**Widefield Parks and Recreation
Facility Expansion**
705 Aspen Drive, Colorado Springs, CO 80911
Widefield School District 3
1820 Main Street
Colorado Springs, CO. 80911

**RECORD
DOCUMENTS**
Drawn: _____ SL
Checked: _____ JCP
Issued: 30 NOVEMBER 2023
Revised: _____
24 January 2024

**POND GRADING
PLAN**

C7.4

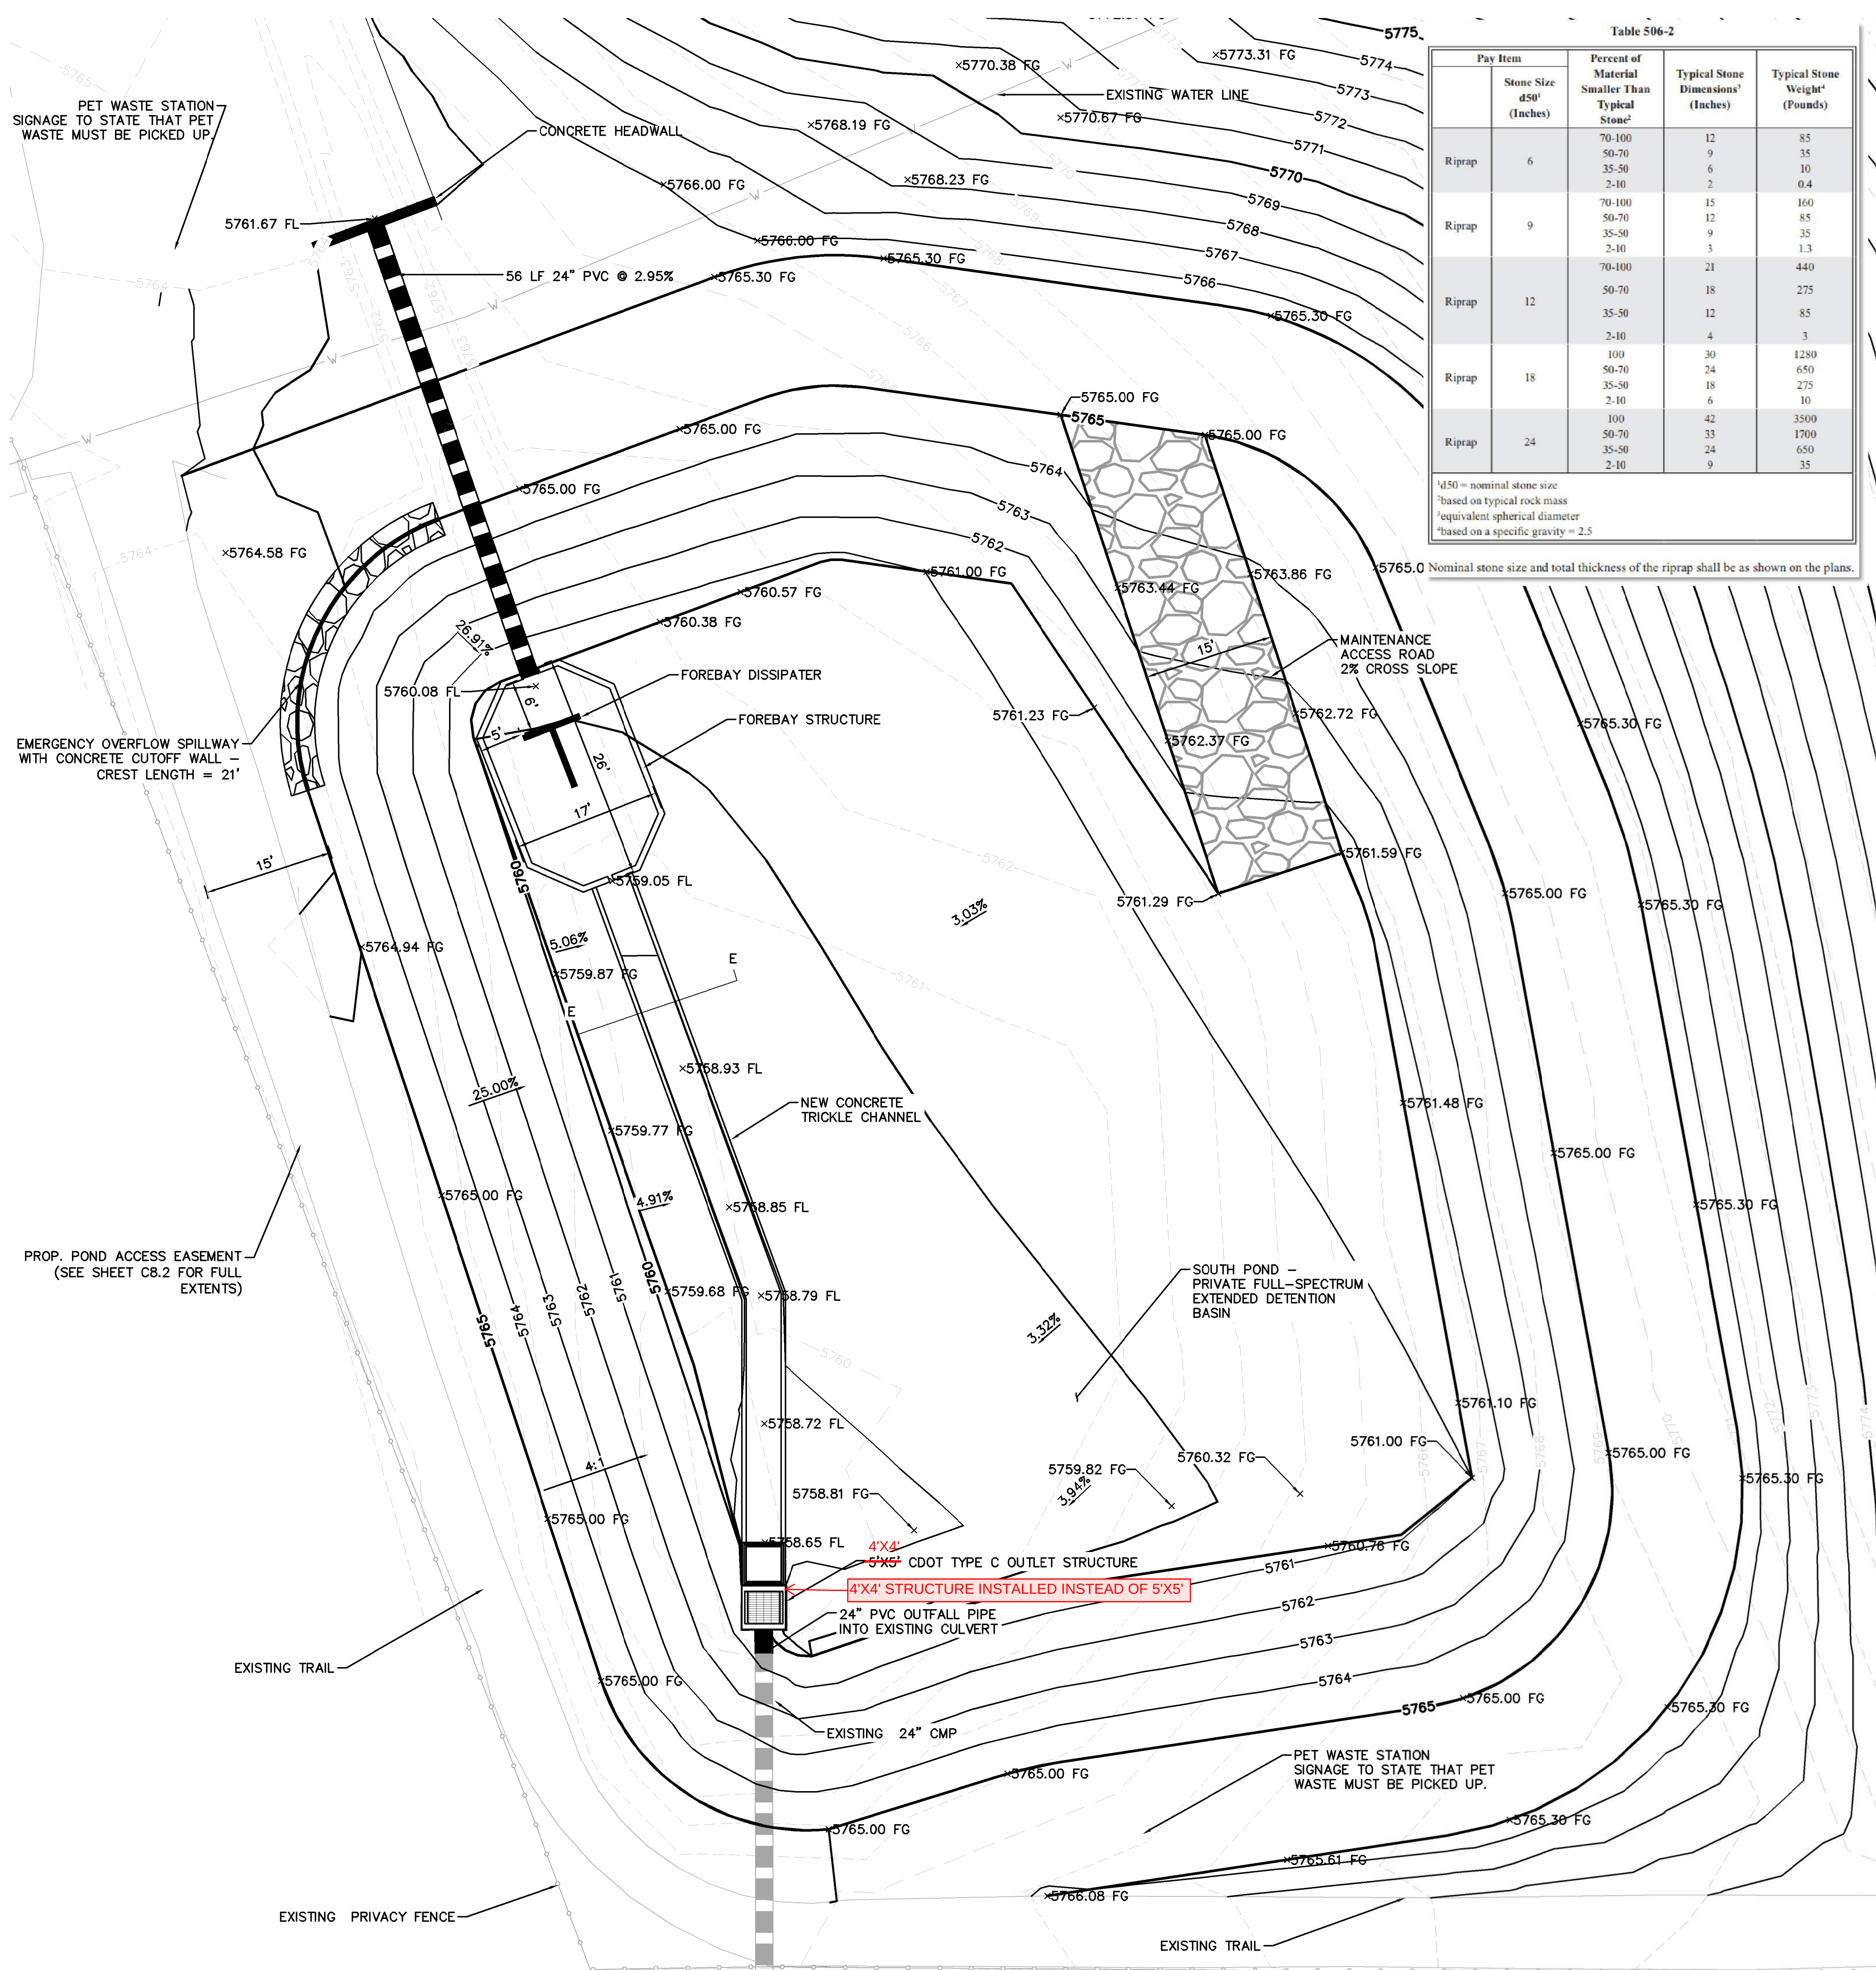
Add Sht C7.5 to this document. All of the as-built plan sheets should be in one PDF, and the calcs and Cert Letter in another. And then uploaded to their respective slots on EDARP.
